Our ref: MP 10\_0107

### **Major Project 10\_0107 – Residential Development Buildings 1, 2 & 3, 61 Mobbs Lane, Epping**

### ADDITIONAL INFORMATION REQUIRED

Project Application  
 A-3103

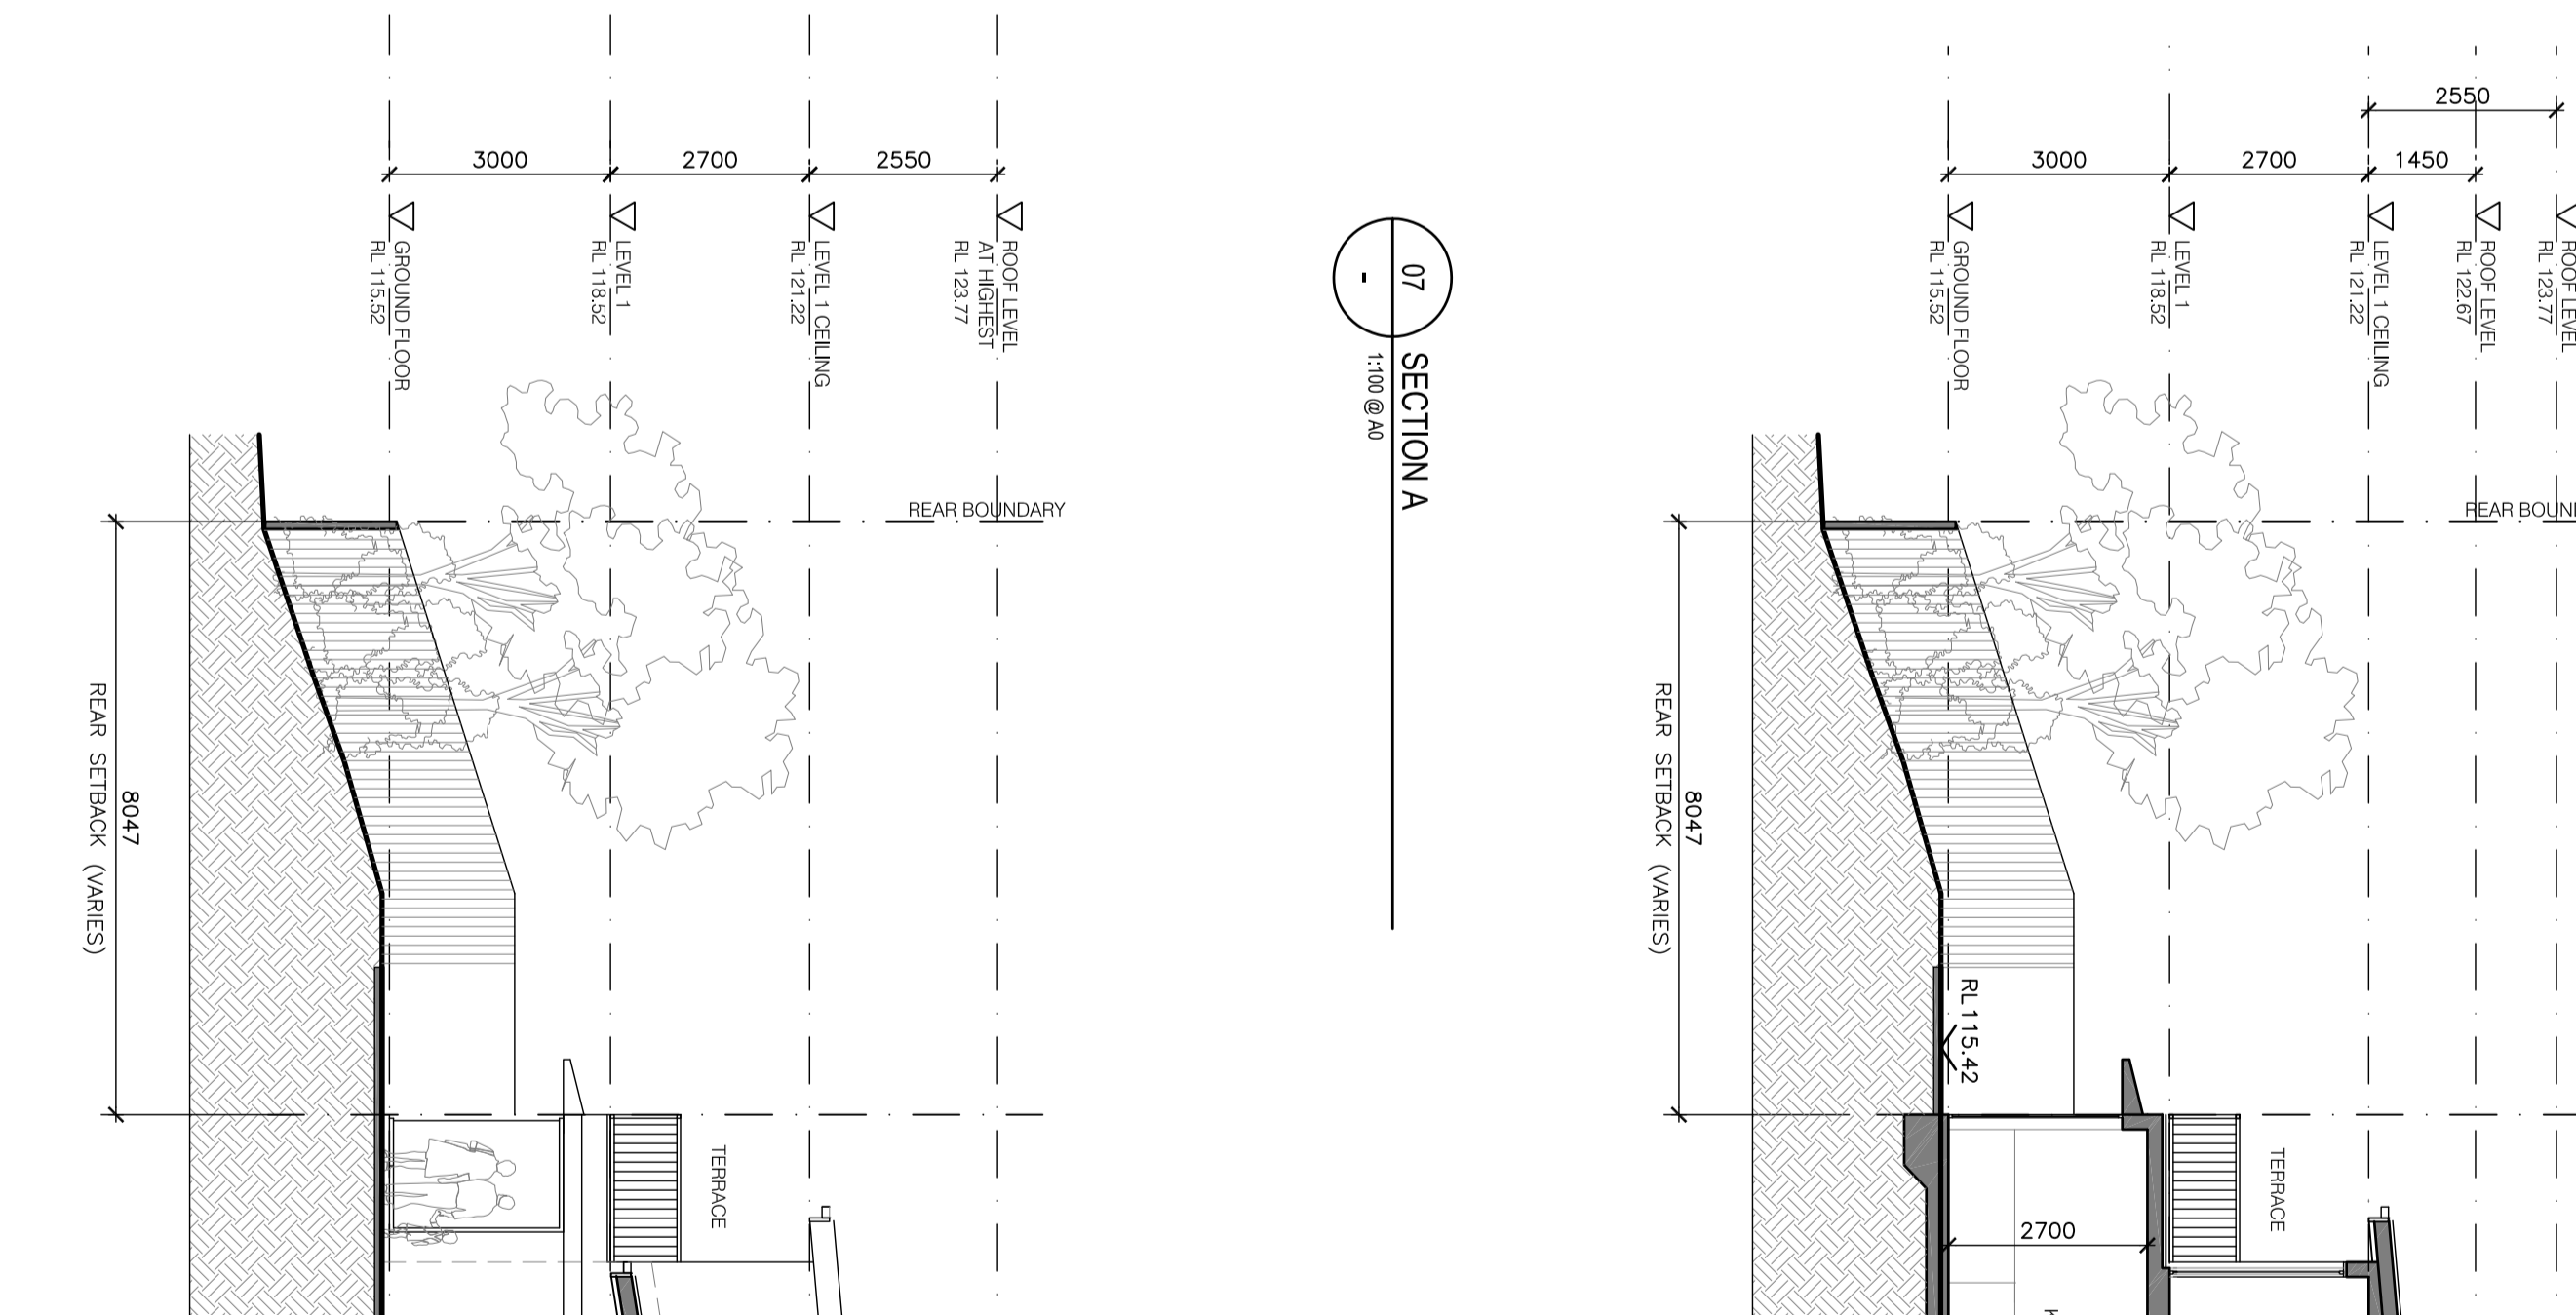
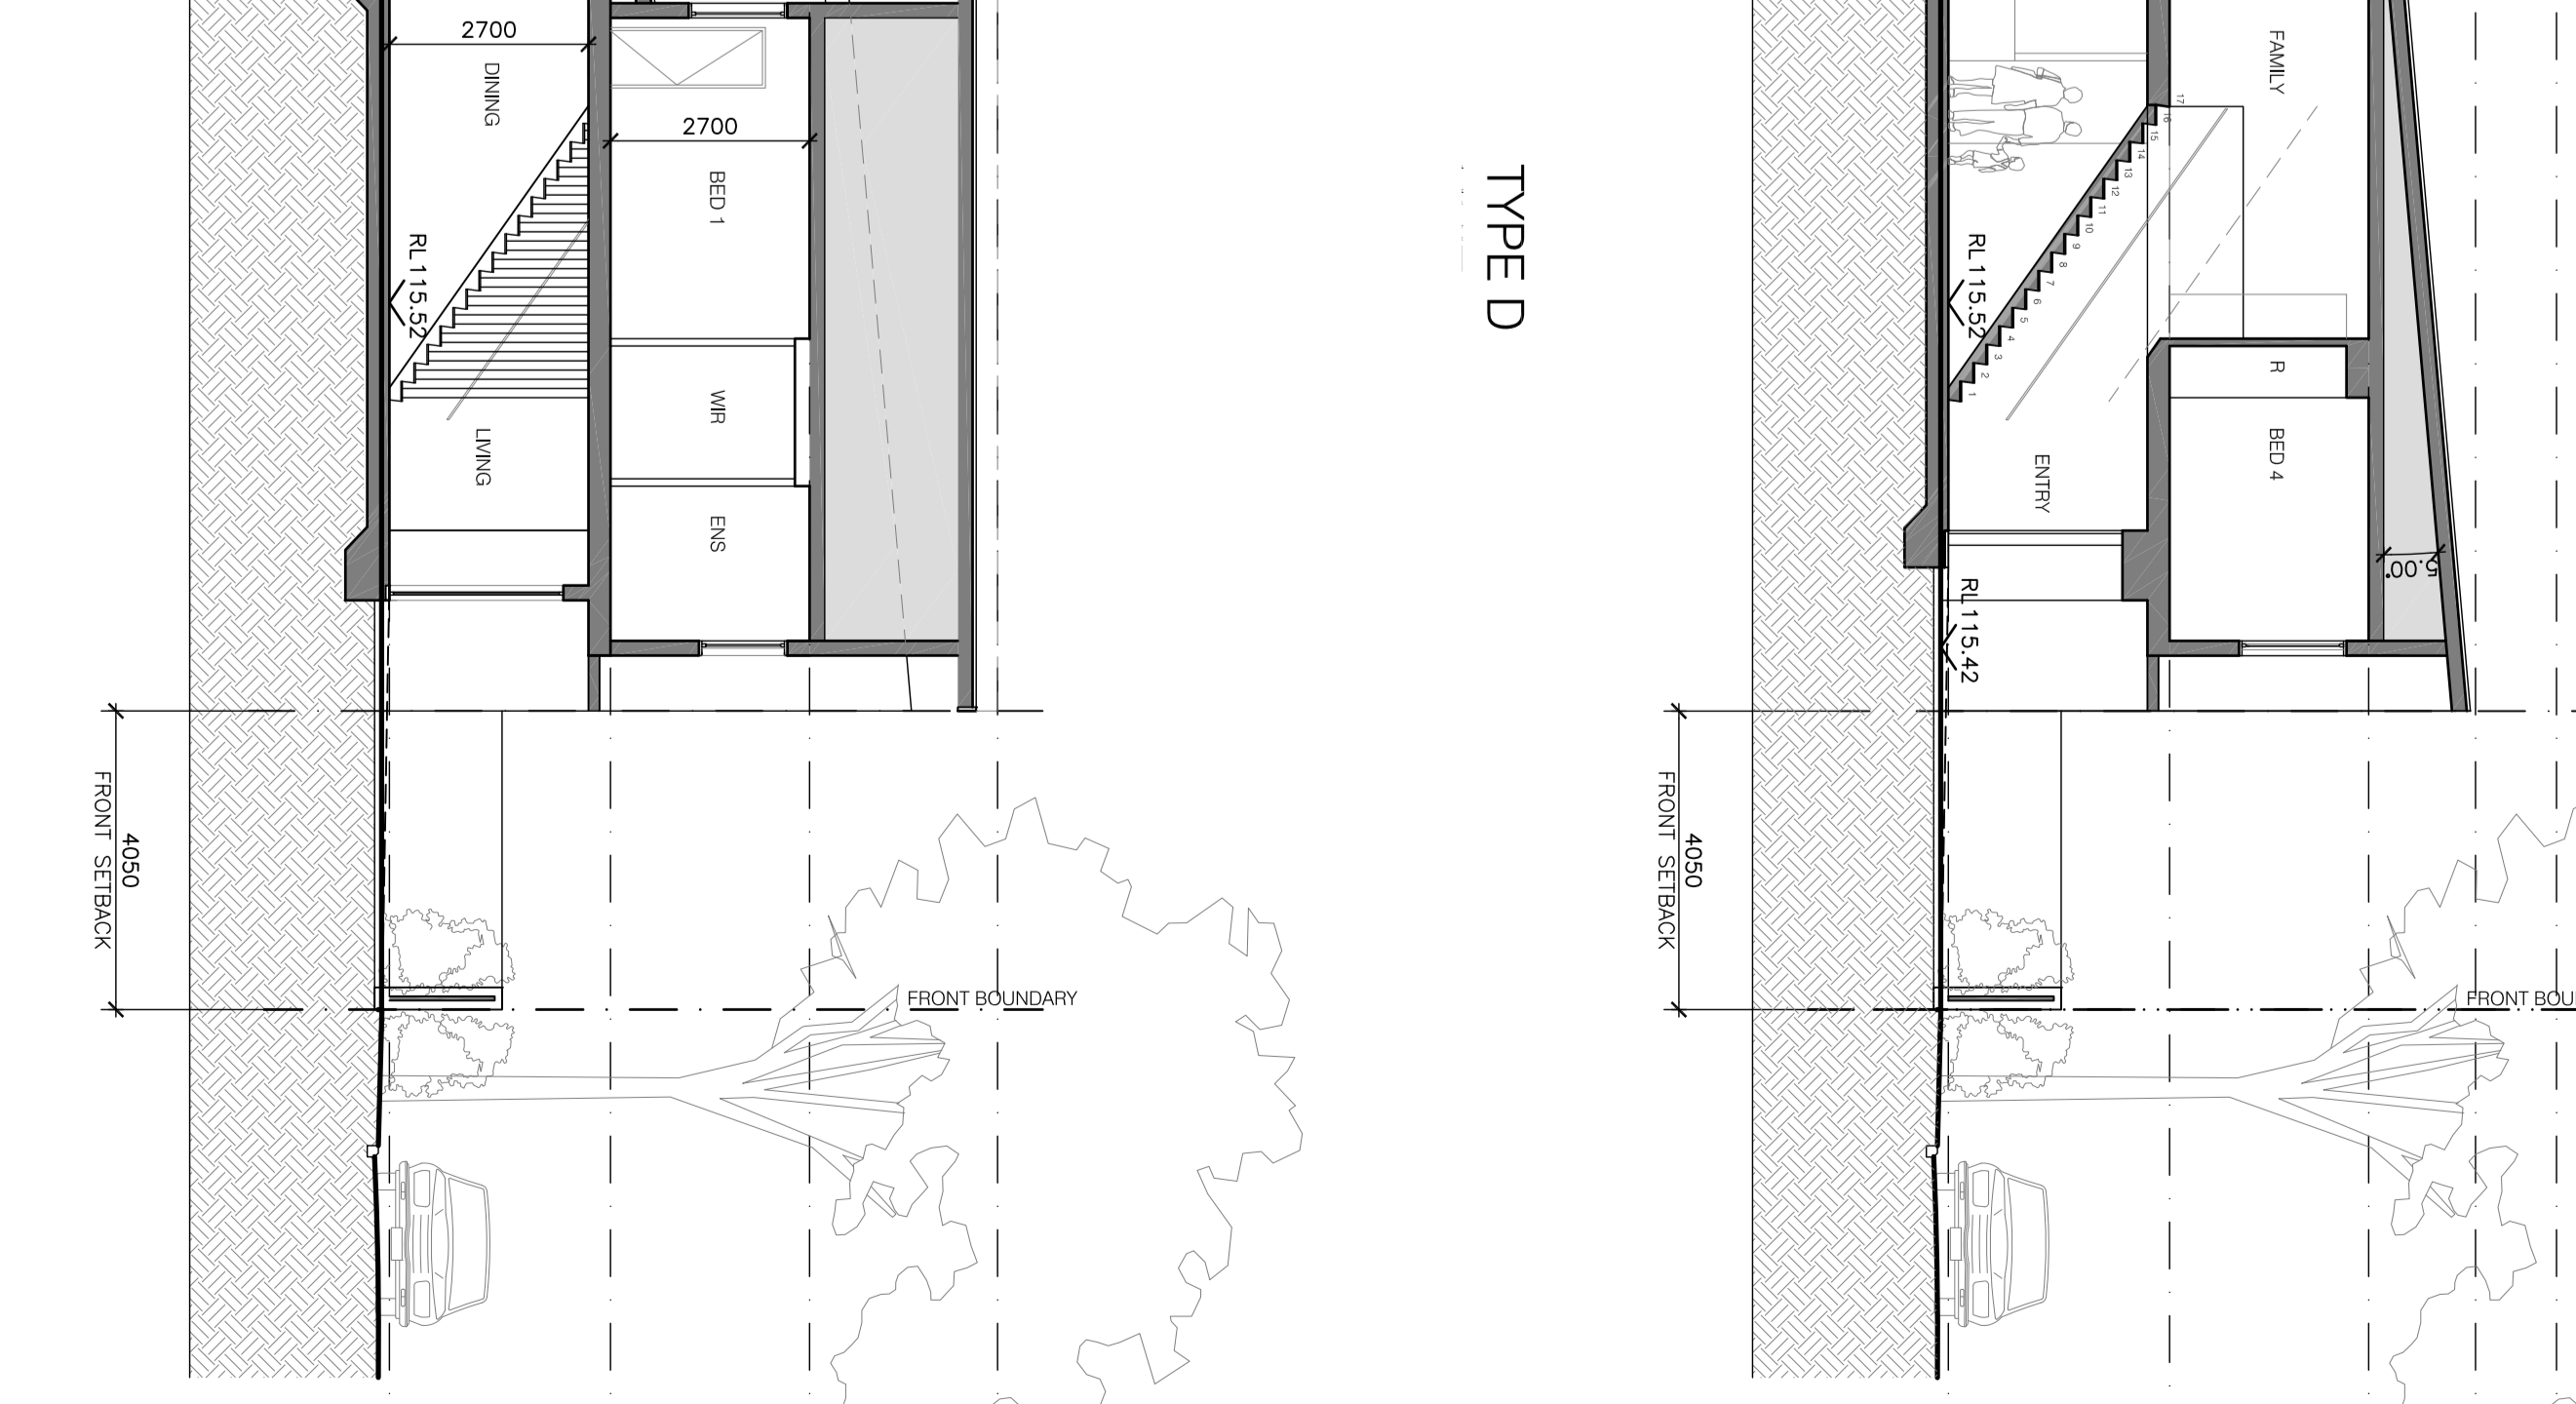
#### **1. Usability of Private Open Space to Building 3**

Consideration should be given to increasing the usability of the rear private open space to those dwellings within Building 3 which experience significant changes in levels.

#### **3. Adaptability**

Confirmation is requested as to the potential compliance of the dwellings within Building 3 with AS 4299 Adaptable Housing.
